Rezoning Transportation Analysis

Petition Number: #2022-109

Date	Description
11-28-22	First Review (IW)

TECHNICAL  
DATA SHEET

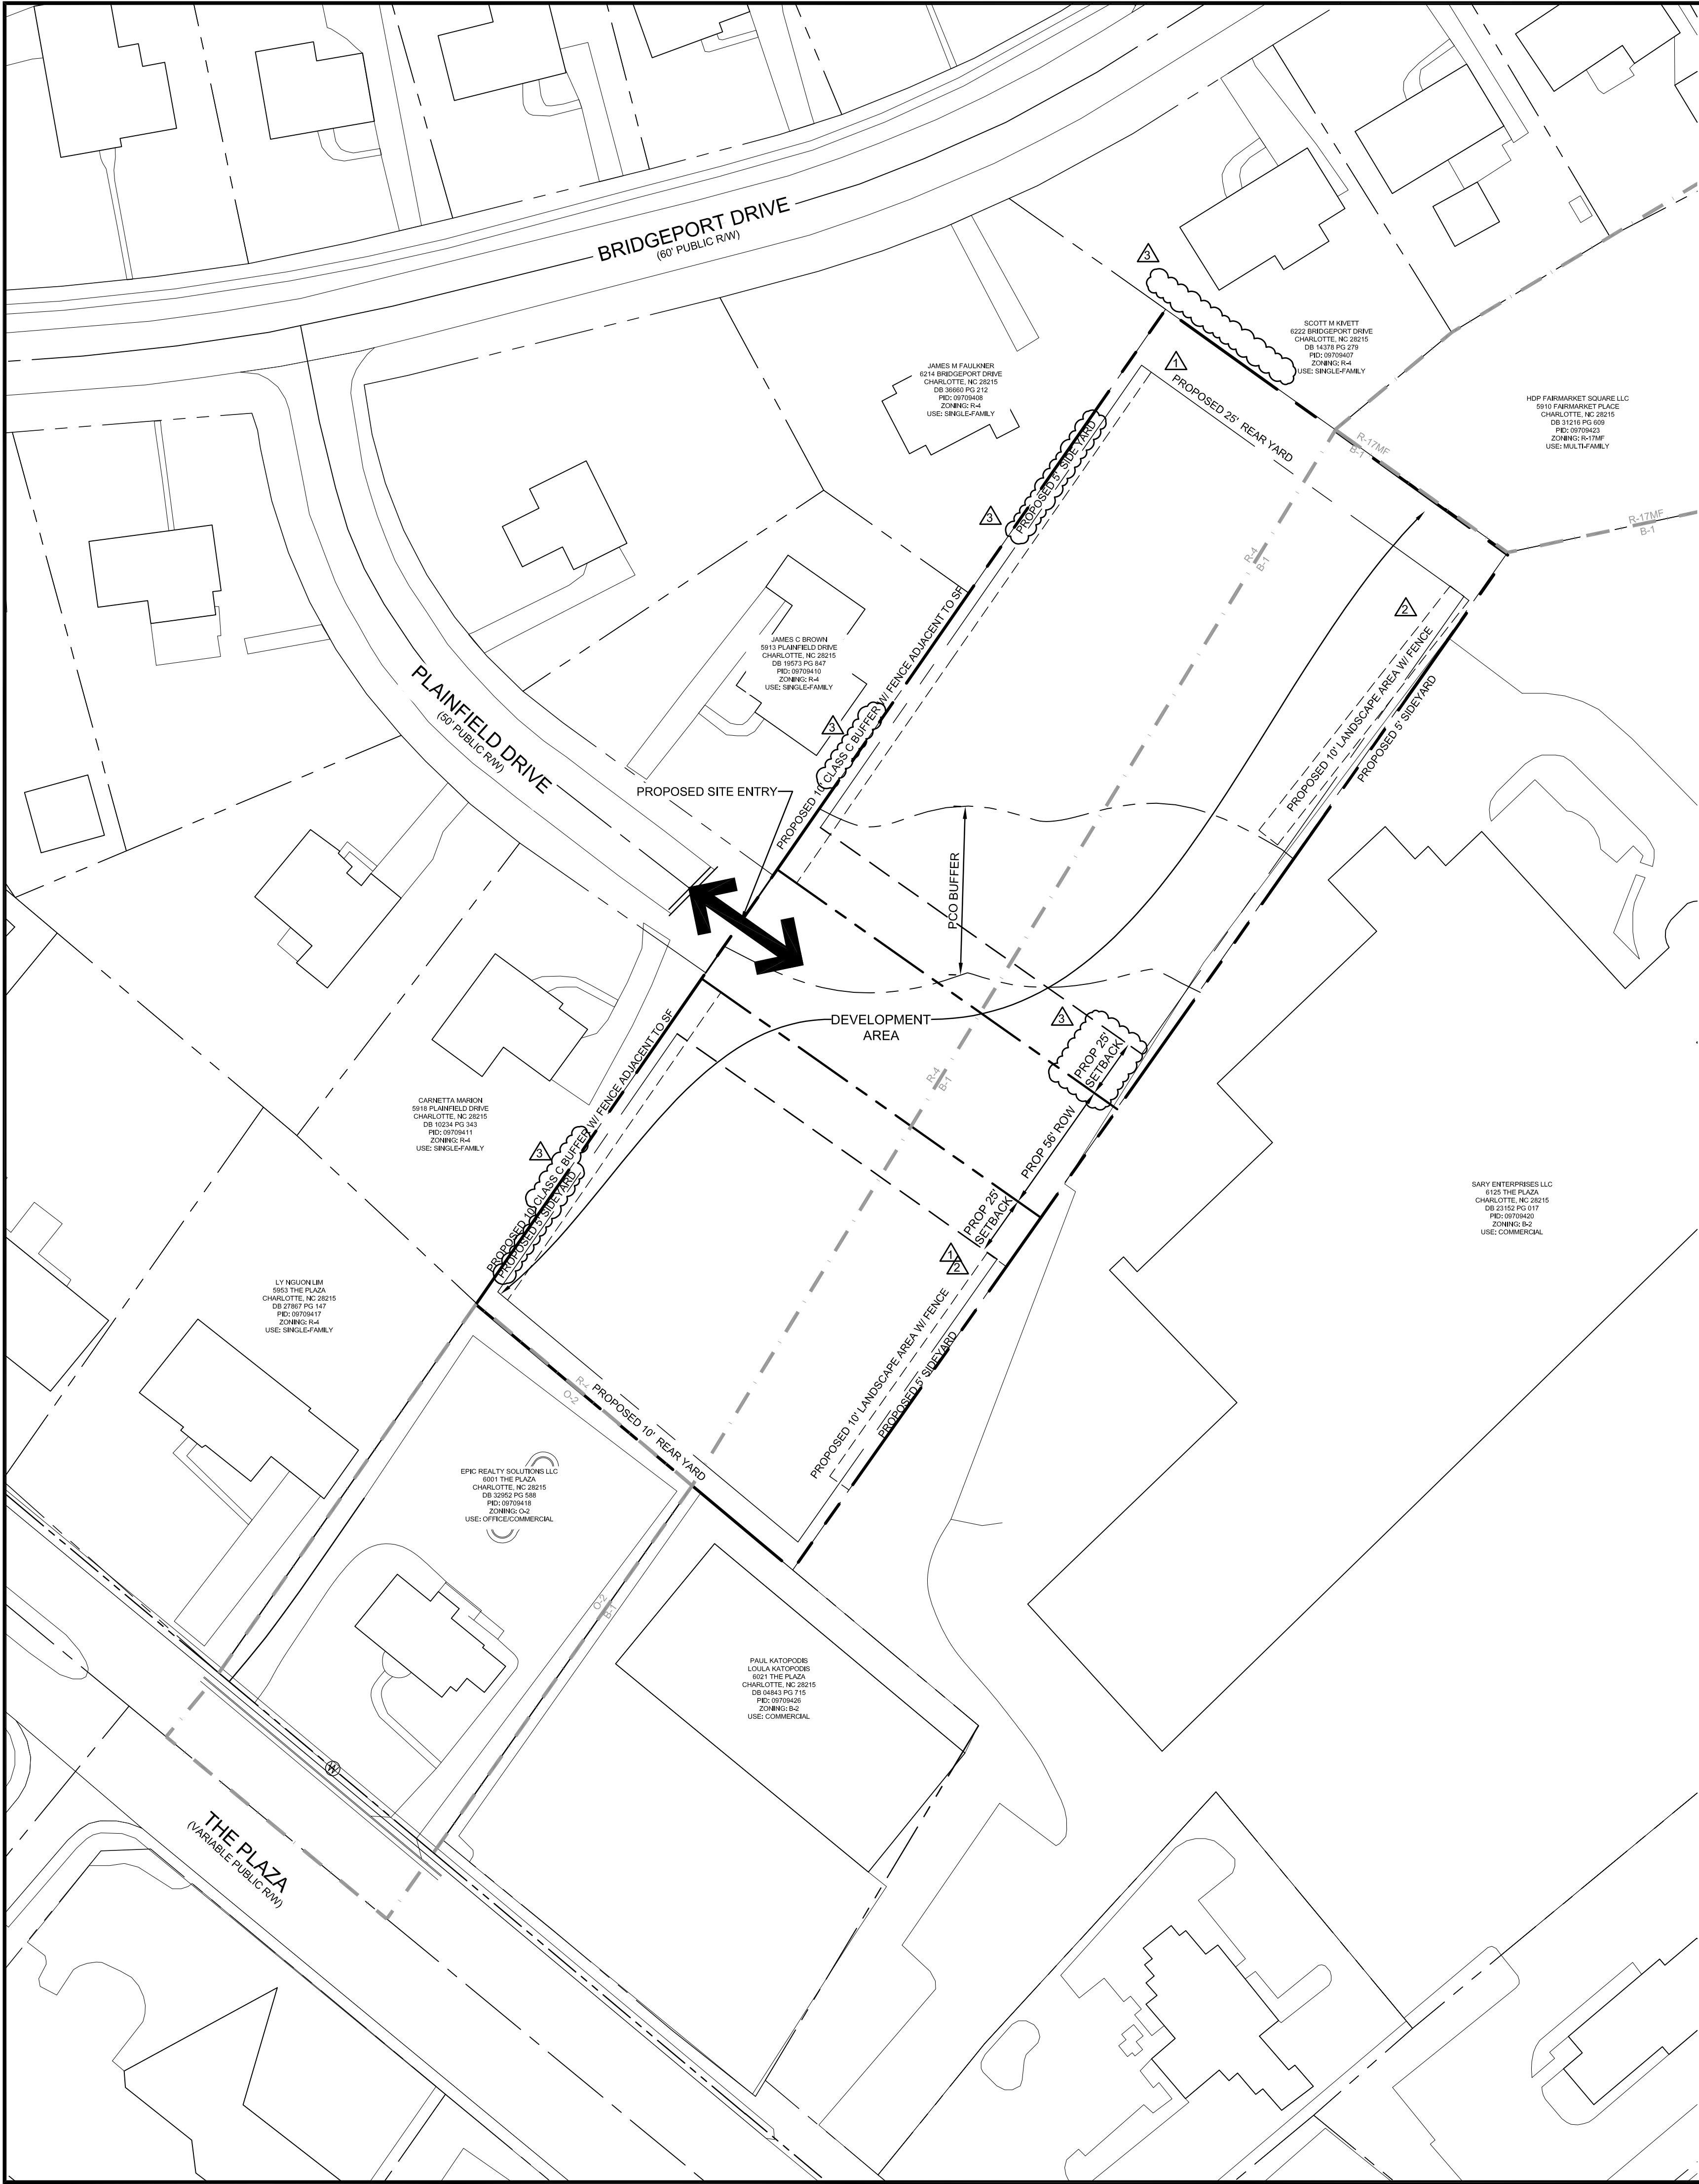
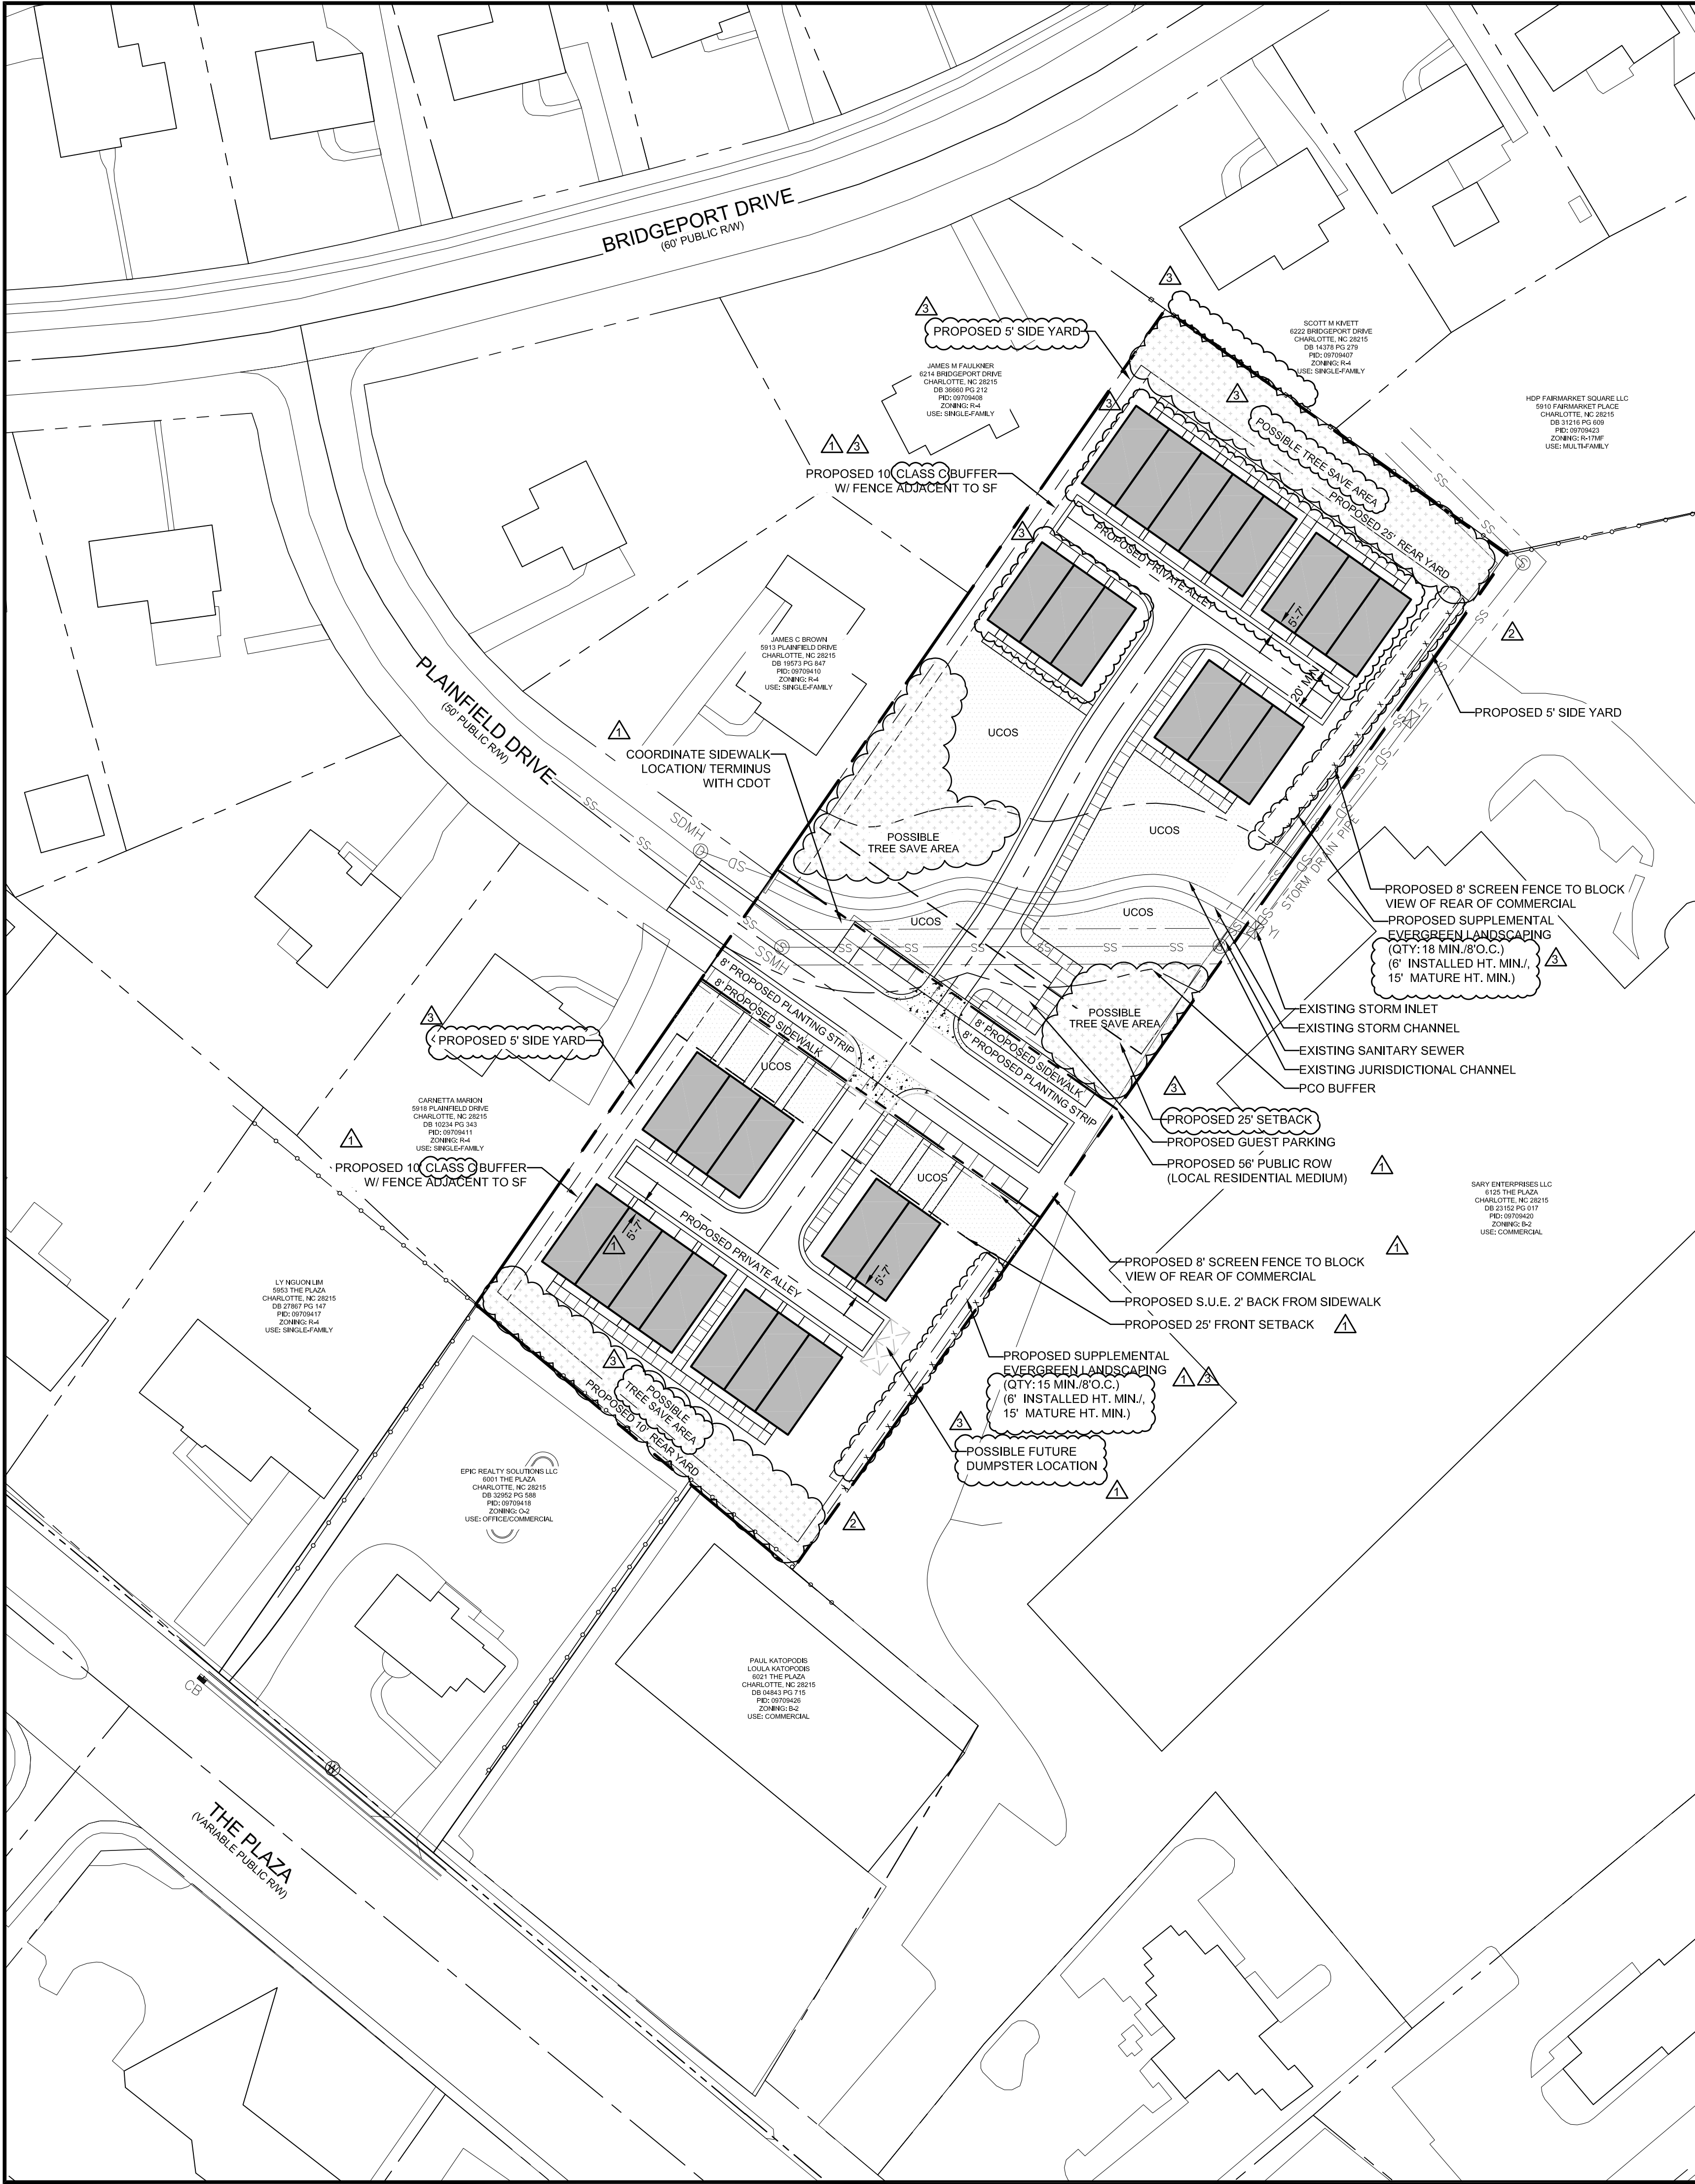
1. **Curbline:** The proposed zoning district has a setback measured from back of the existing or proposed future curbline.
 - a. **Plainfield Drive:** The future location of curb and gutter is in its existing location.

Label and dimension the curb and gutter from the centerline for each road on the site plan.

3. Revise site plan and conditional note(s) to commit to construct an 8-foot planting strip, and 8-foot sidewalk on both sides of all public roads per Chapter 20. The site plan shall label and dimension both items from the back of curb and gutter and road centerline.
4. The proposed dwelling units exceeds 12 per acre. Per Chapter 20 Subdivision ordinance, site plan and conditional note(s) revisions are needed to commit to construct an 8-foot planting strip, and 8-foot sidewalk along all public roads. The wider sidewalk also meets the Charlotte WALKS Policy.

Reference (CLDSM standard detail U-02.19) for residential medium street typical.

5. Revise the plan and conditional note(s) to commit to designing the end of the proposed extension of Plainfield Drive as street stub.
